Reference: H16-0110-17 **Date of Decision:** 26th April 2017
Applicant: Glen Holland Ltd - Pension Plan
Stonegate House
Stonegate
Gedney
Spalding Lincs
PE12 0BY
Location: 1 Woolram Wygate Spalding
Description: Change of use from office accommodation to house of multiple occupation (HMO)

South Holland District Council hereby give notice that this application has been REFUSED for the above proposal for the following reason(s):

BLOCK PLAN 1:200

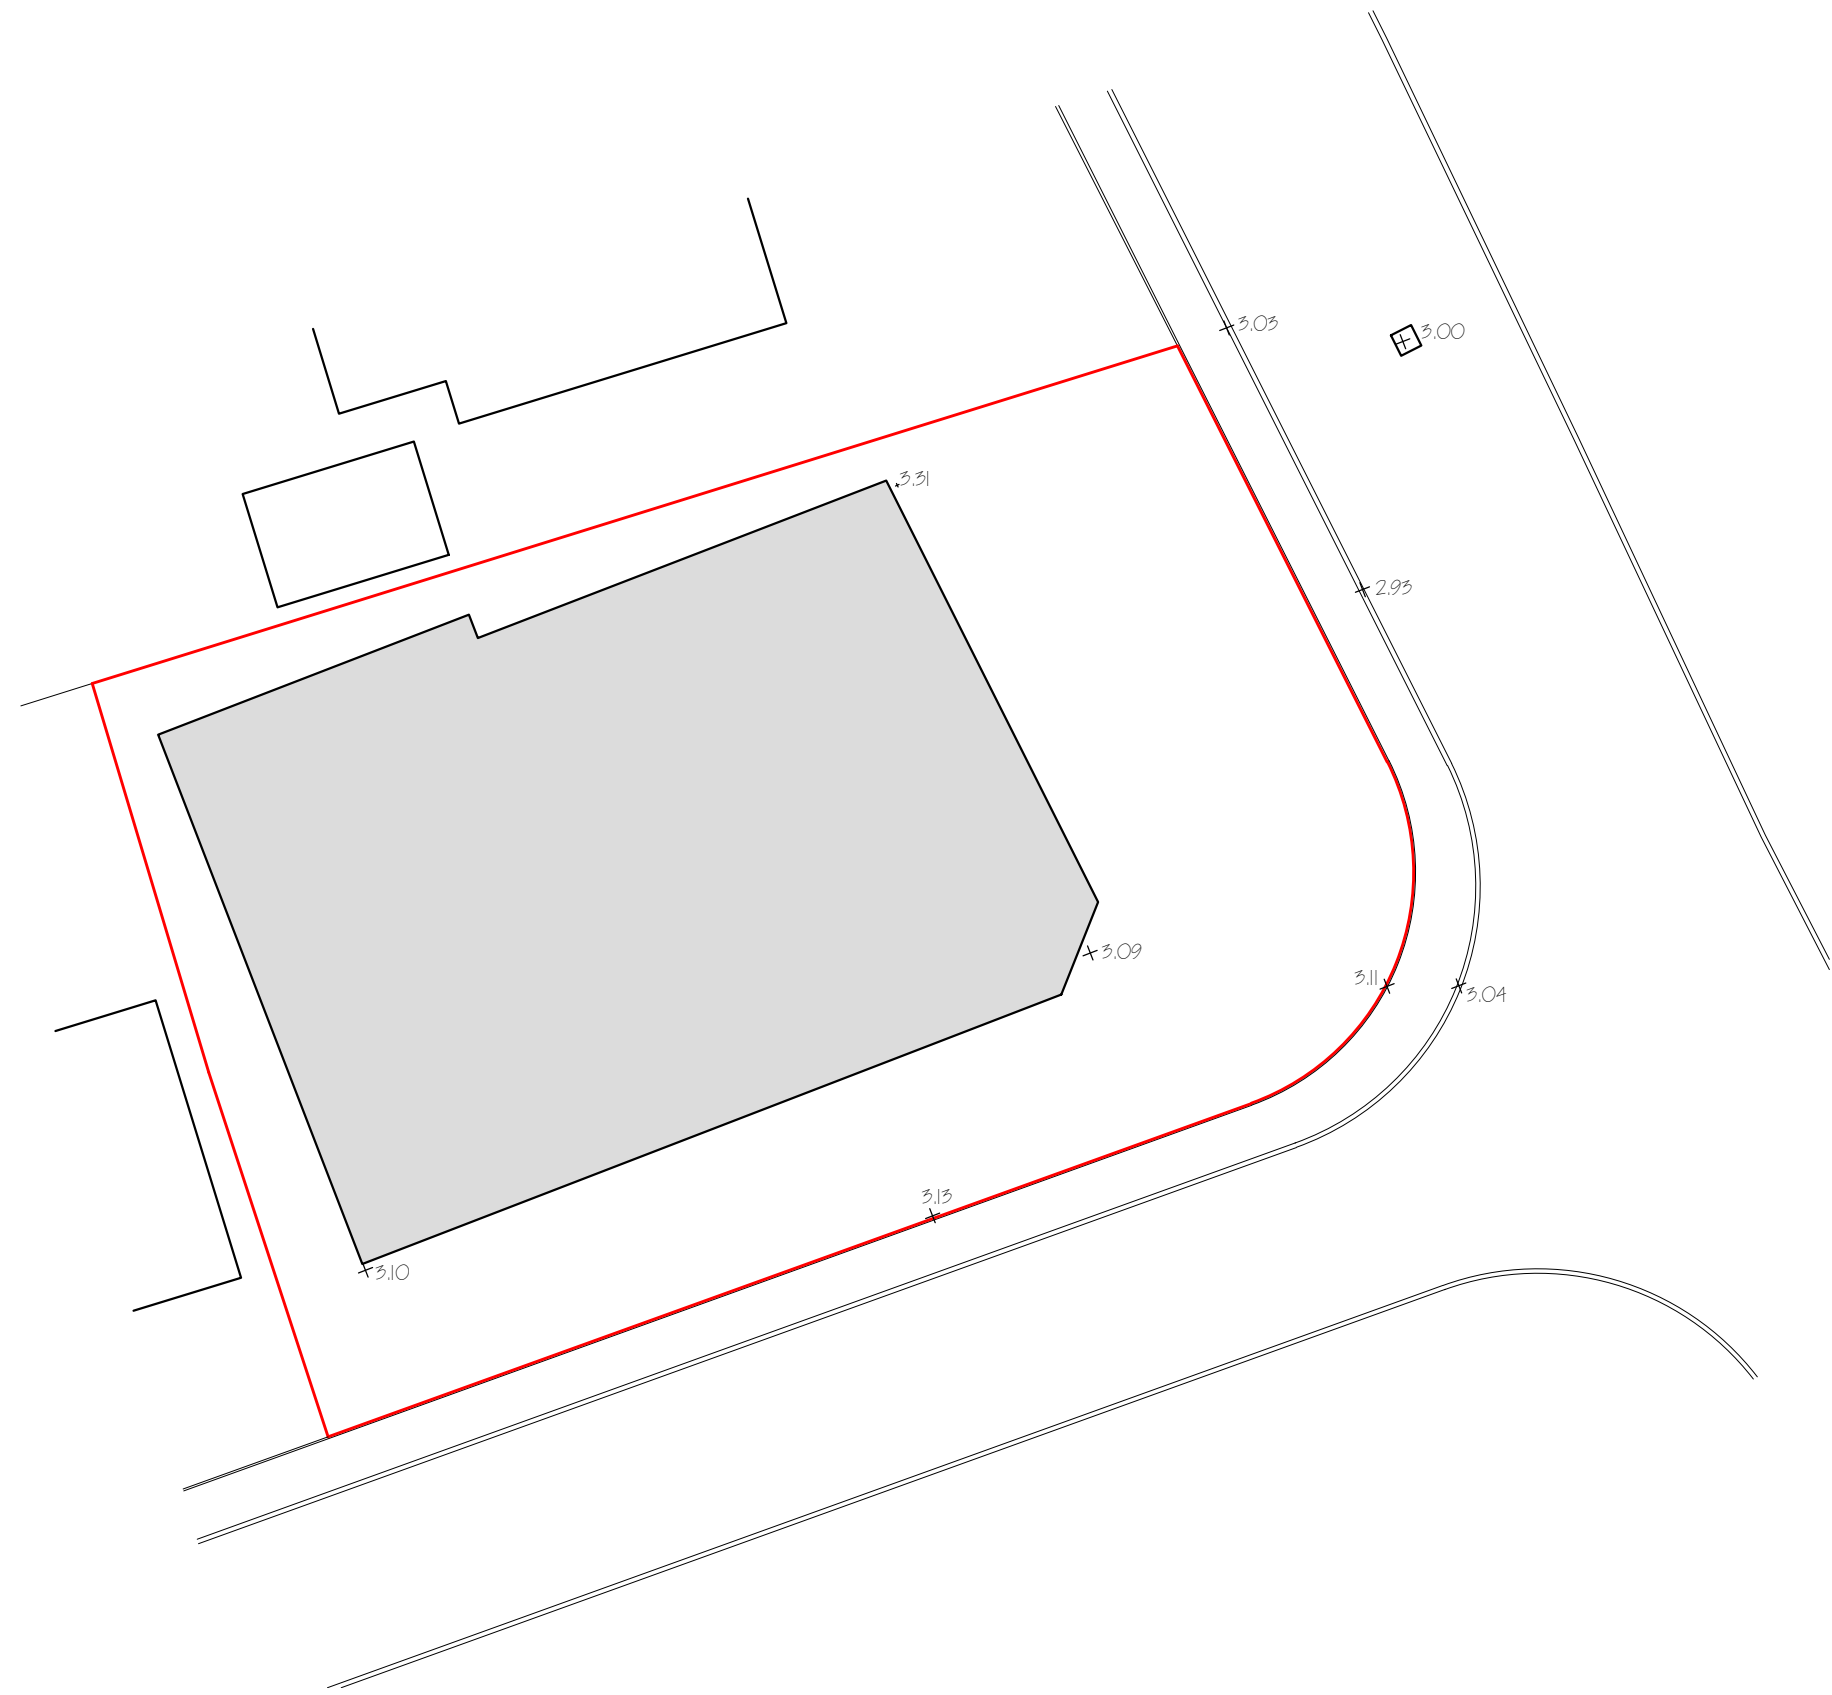
- 2 The application does not provide sufficient evidence to demonstrate that this former office building would be able to provide sufficient off-street parking to accommodate the number of vehicles it would reasonably be expected would be owned or would routinely be used by the fifteen persons it is proposed would reside at the property. Accordingly it is considered likely that vehicles would routinely be indiscriminately parked on the highway in the vicinity of the property where high demand of parking availability is in place due to the primary schools and such parking of vehicles would unreasonably obstruct the safe

and free passage of both pedestrians and drivers. As such the proposal would be contrary to Policy SG16 of the South Holland Local Plan 2006.

FLOOR PLAN - PROPOSED
LOCATION PLAN

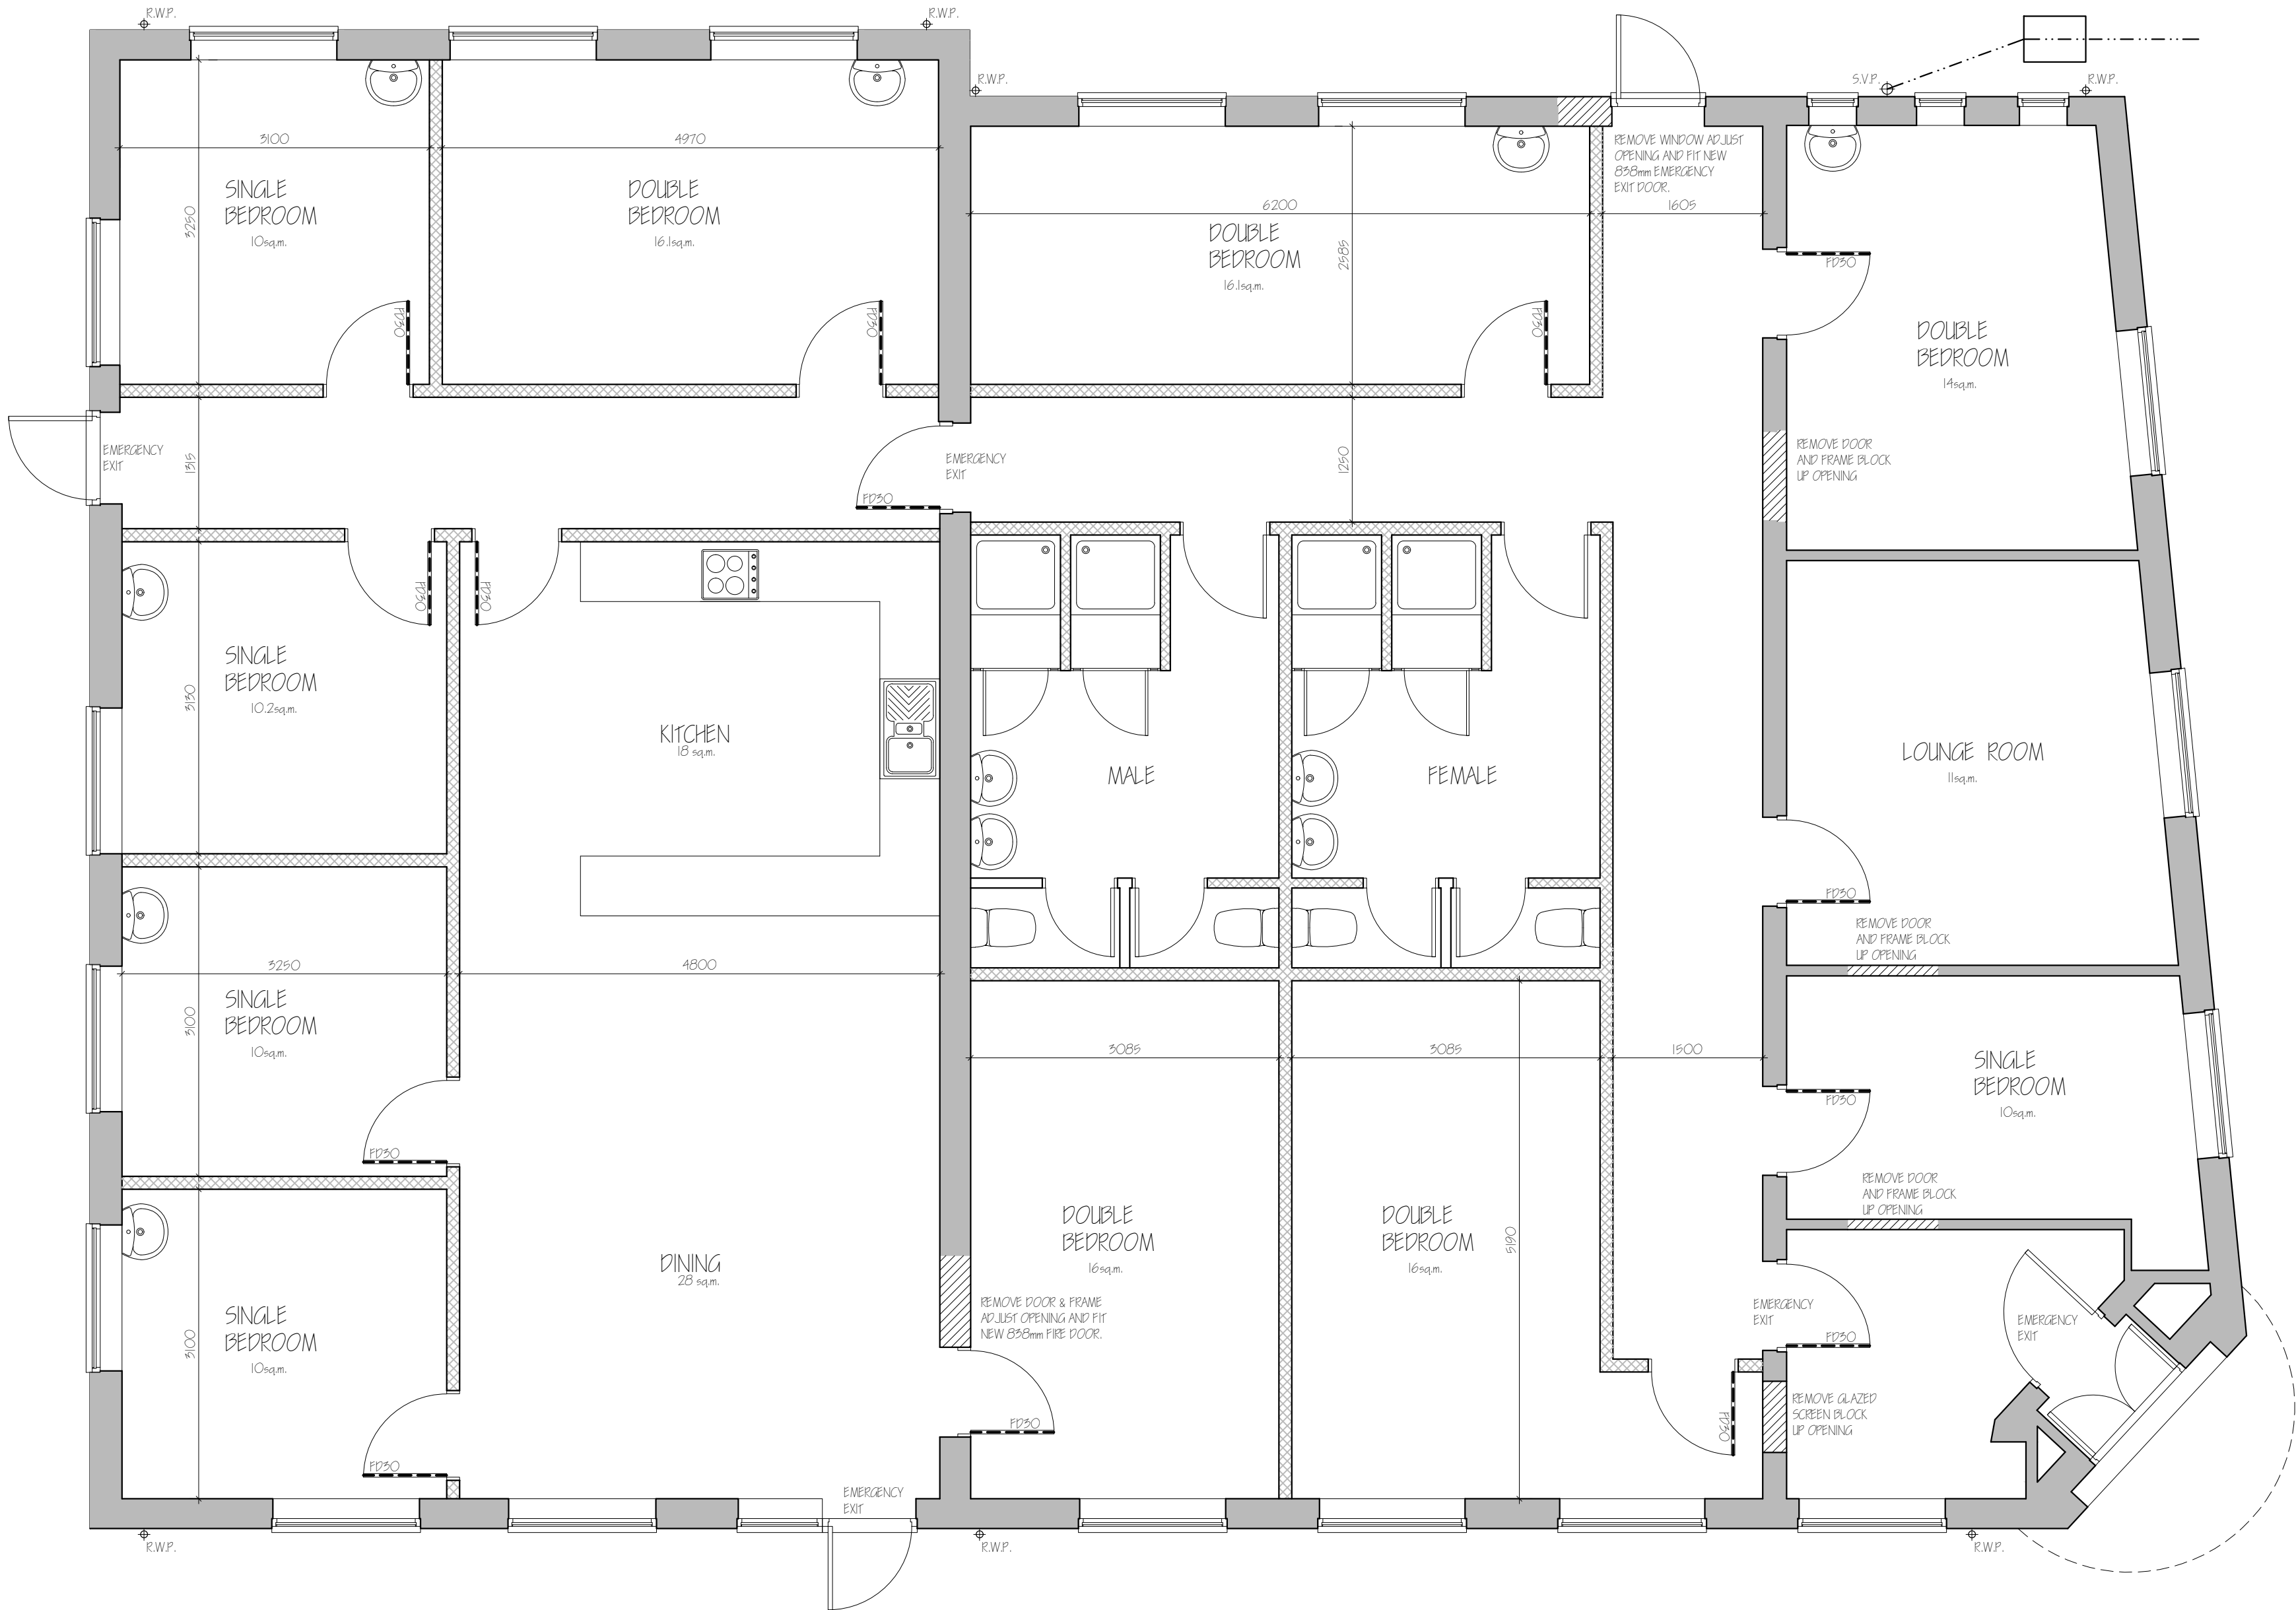
- 1 The use of this building as a House in Multiple Occupation for up to 15 people would be contrary to Policies HS18 and SG17 of the South Holland Local Plan 2006 due to over-intensification of the use of the site likely to give rise to flows of people within a largely residential area characterised by modest housing in single family occupancy. Furthermore, the poor layout shown in the floor plan would be harmful to both the residents of the dwelling and the amenity of the vicinity on the account of insufficient dimensions of communal areas and facilities (dining and lounge rooms, bathrooms).
